Mr Anthony Roberts MP  
Minister for Planning, Minister for Housing, Special Minister of State  
GPO Box 5341  
Sydney NSW 2001

9 January 2018

**Request for advice  
Stage 1 State Significant development application  
for over station development at Martin Place (SSD 8351)**

**NORTH ELEVATION (MARTIN PLACE)
ENVELOPE DRAWINGS**

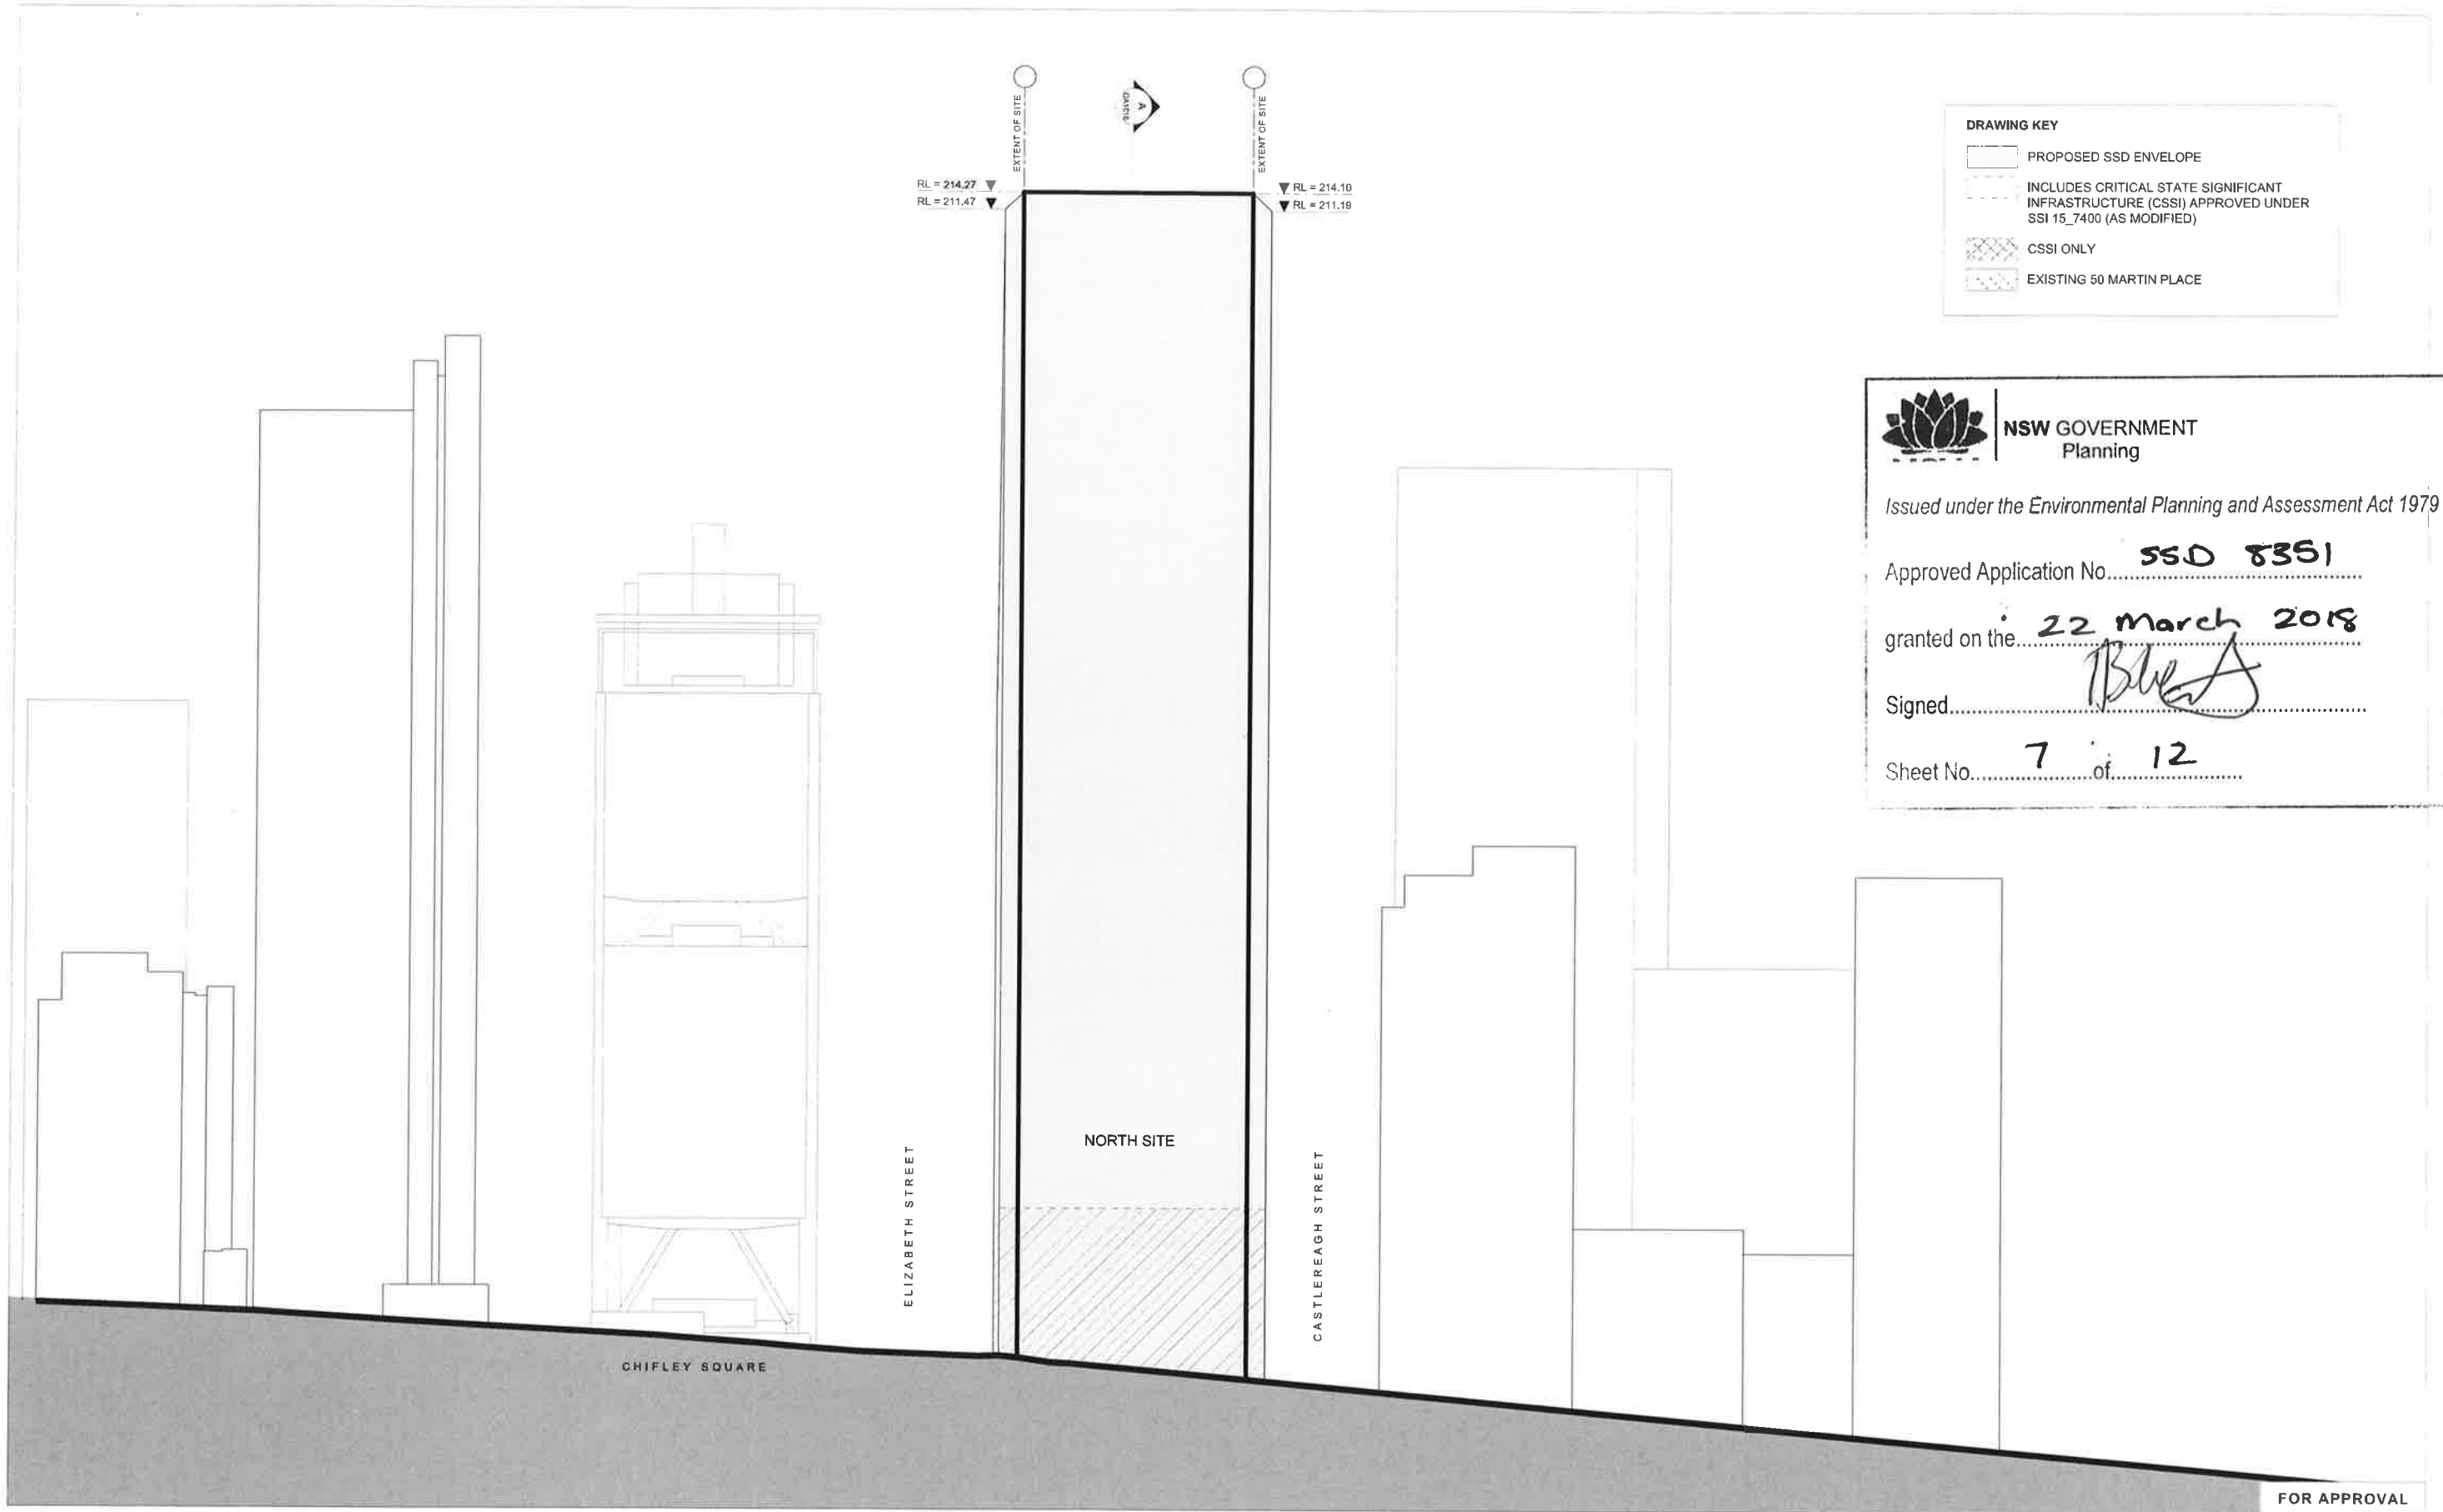
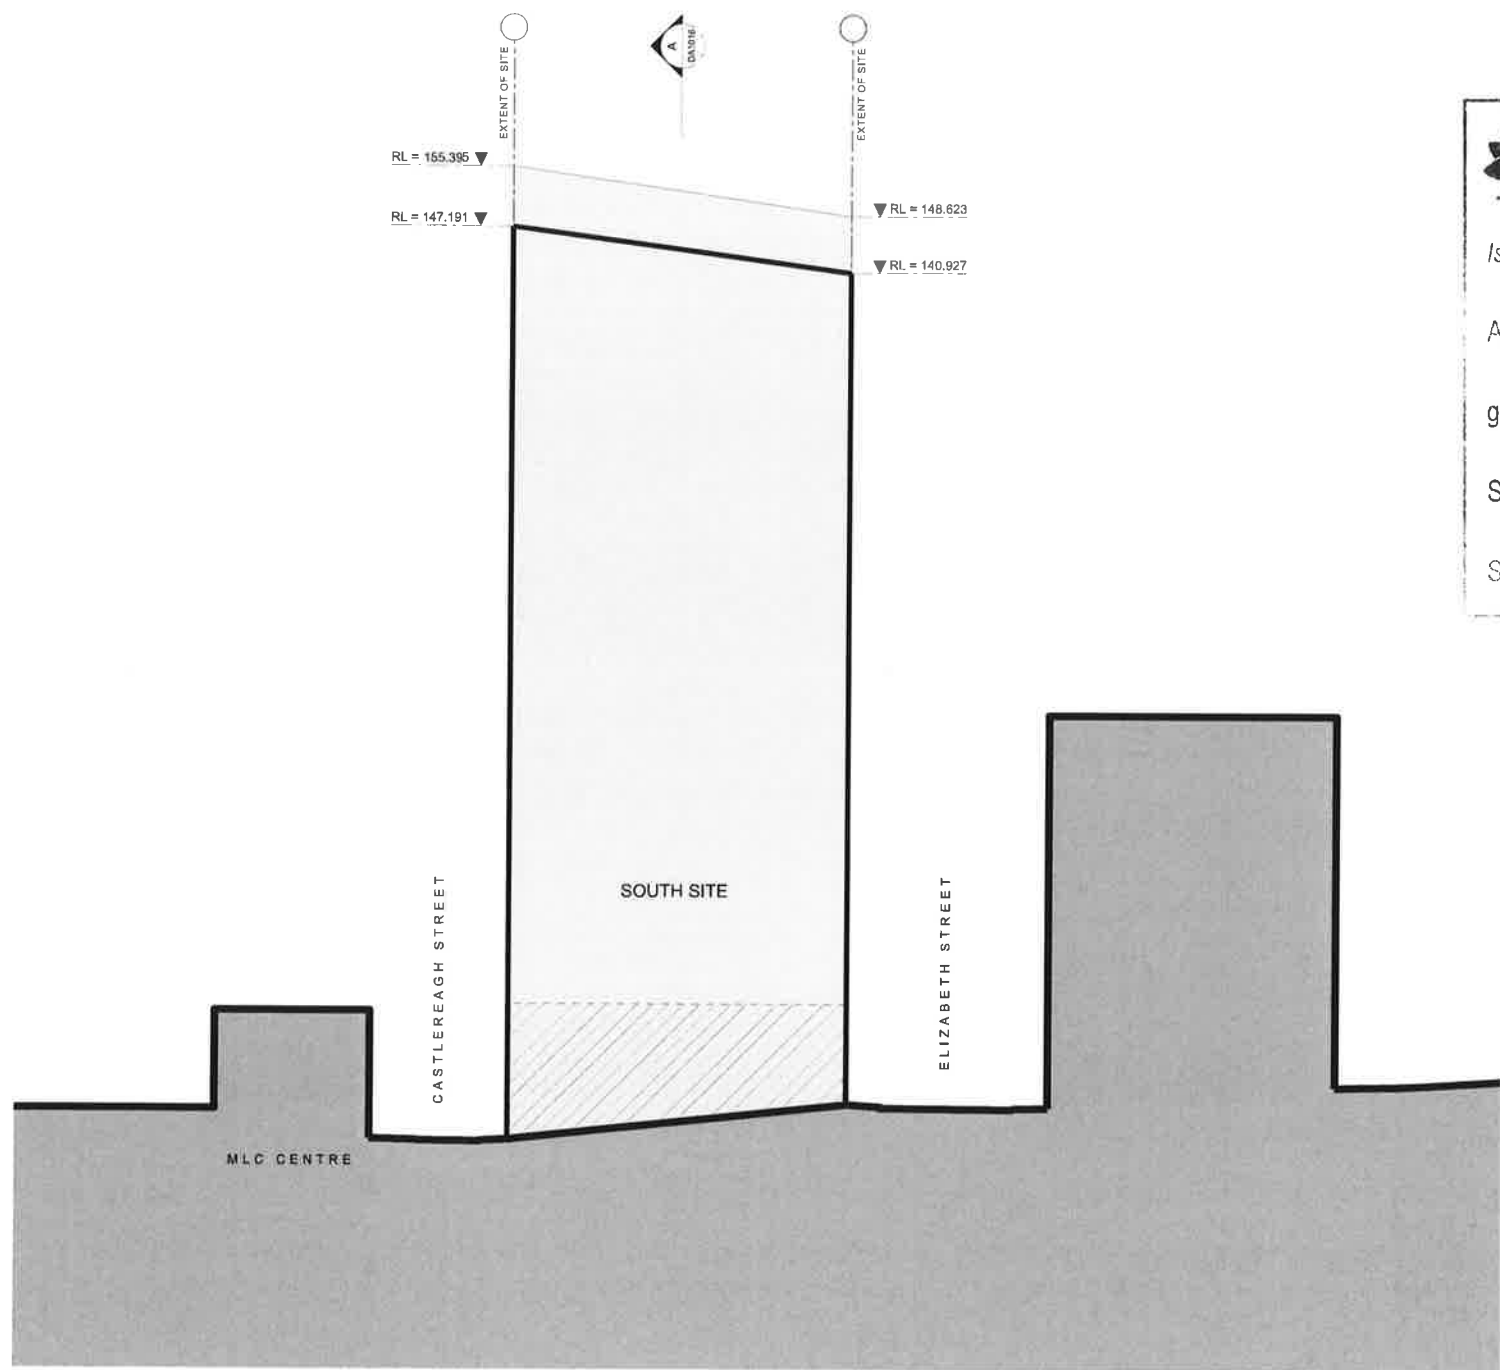
The Commission considers that the applicant's proposed envelopes, particularly for the north building, could result in very large, bulky development. The indicative design scheme shows a massive north building attached to and tapering above 50 Martin Place with little relief and limited opportunities for mid-block pedestrian permeability at ground level. The Commission considers that such an approach would have a significant negative impact on the urban outcome and be distinctly out of character with the surrounding buildings and their context.

The Commission acknowledges the Department's view that very careful design resolution will be required at stage 2. However, the Commission considers that the street walls for both north and south sites, the boundary setback from 50 Martin Place at podium level of the northern tower and the southern tower setback to Martin Place are worthy of strong reinforcement by way of physical setbacks, and that these should be incorporated into the concept approval for the building envelopes. In this respect, the City's suggestion of 'at least' a four-metre setback above the podium appears to the Commission to be a suitable compromise between the eight metres that would otherwise be specified by the City, and the transformative urban and commercial opportunities presented by the site.

1. The proposed building envelopes should be modified by way of a boundary setback at podium height of at least four metres along Elizabeth and Castlereagh Streets (for both the north and south towers) and a setback from 50 Martin Place at podium height of at least four metres to the southern boundary of the north tower;
2. The maximum envelope above the podium for the southern tower be setback 25 metres from the northern site boundary of Martin Place;
3. A tower to ground typology for the Hunter Street elevation could be appropriate only if it can be demonstrated that wind conditions will be improved as a result. Simply maintaining the current unsatisfactory conditions is not considered acceptable.
